Side extension for garage & store with guest suite over. This application affects the character & appearance of the Aldwick Bay Conservation Area.

91 The Fairway Aldwick

Thank you for your internet representation made on 11th March 2015 which has been recorded as '**an objection**' with the comments as follows:

DEC 2014
DEG 9A

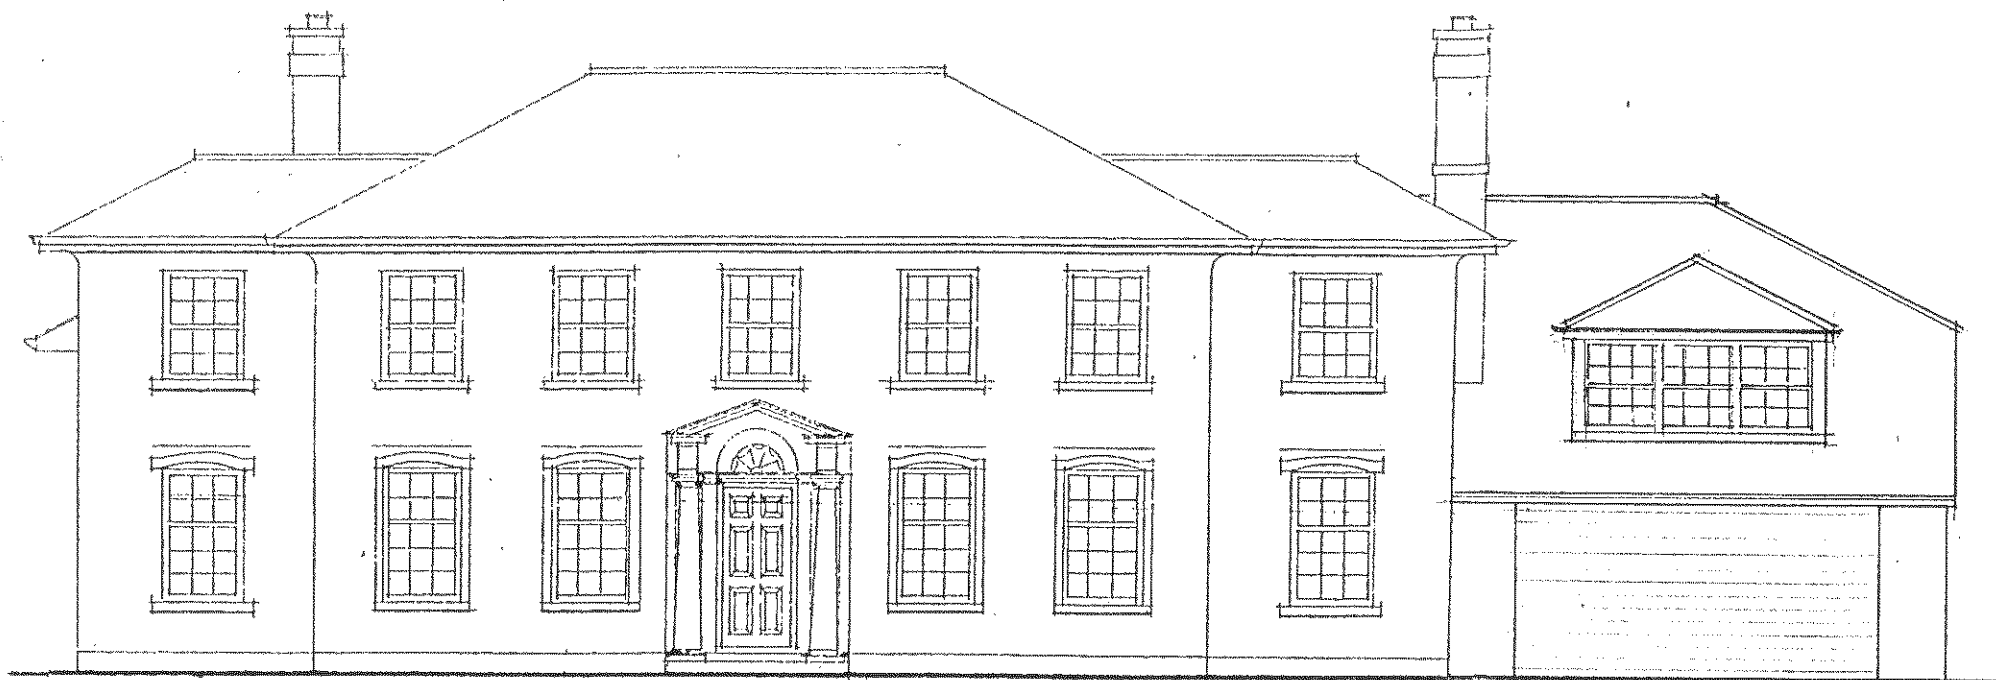
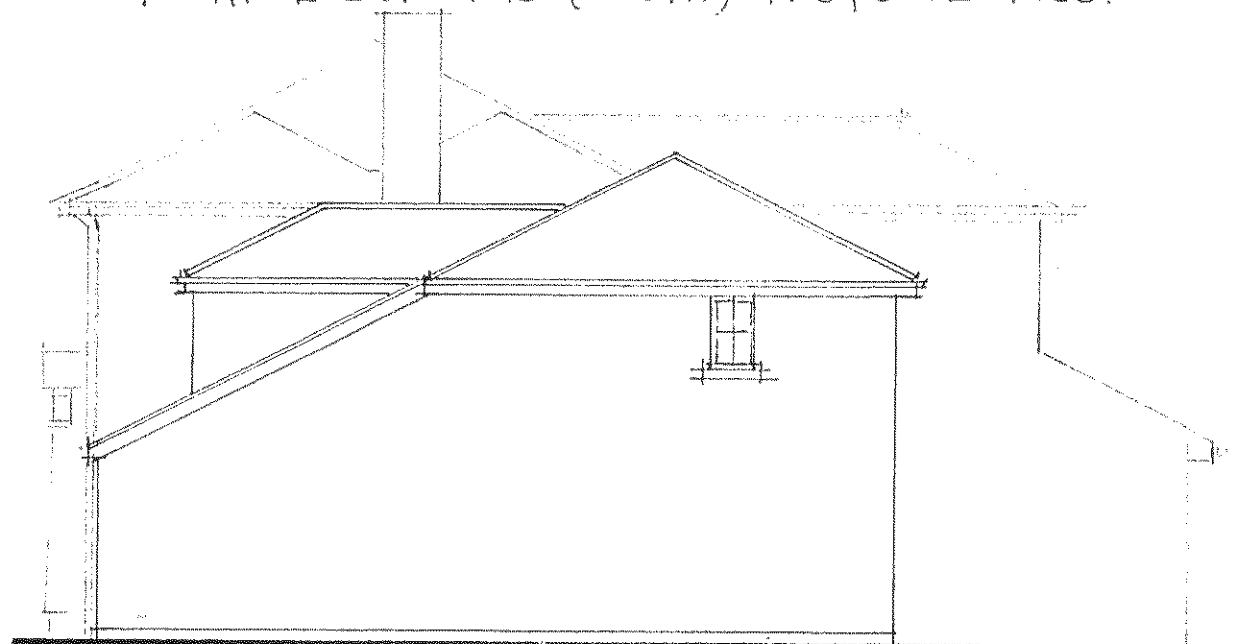
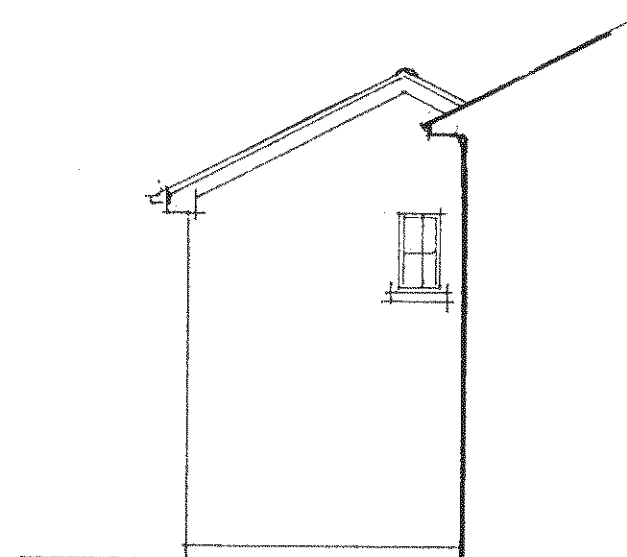
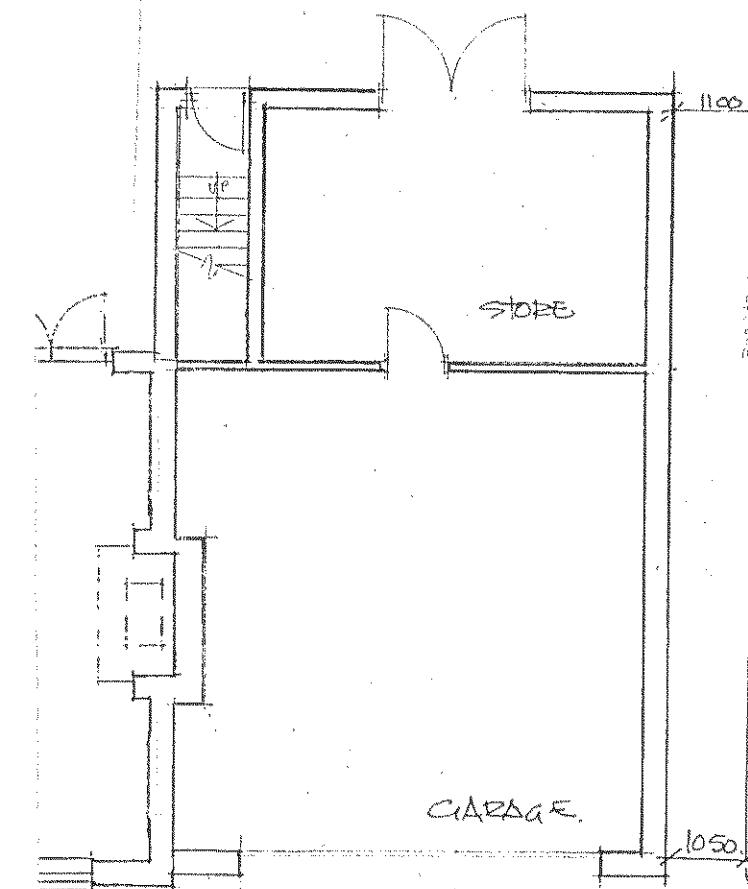
The proposed extension is totally out of keeping with the highly symmetrical mock-Georgian style of the house and I am sure that a decent architect could produce a far more sympathetic design
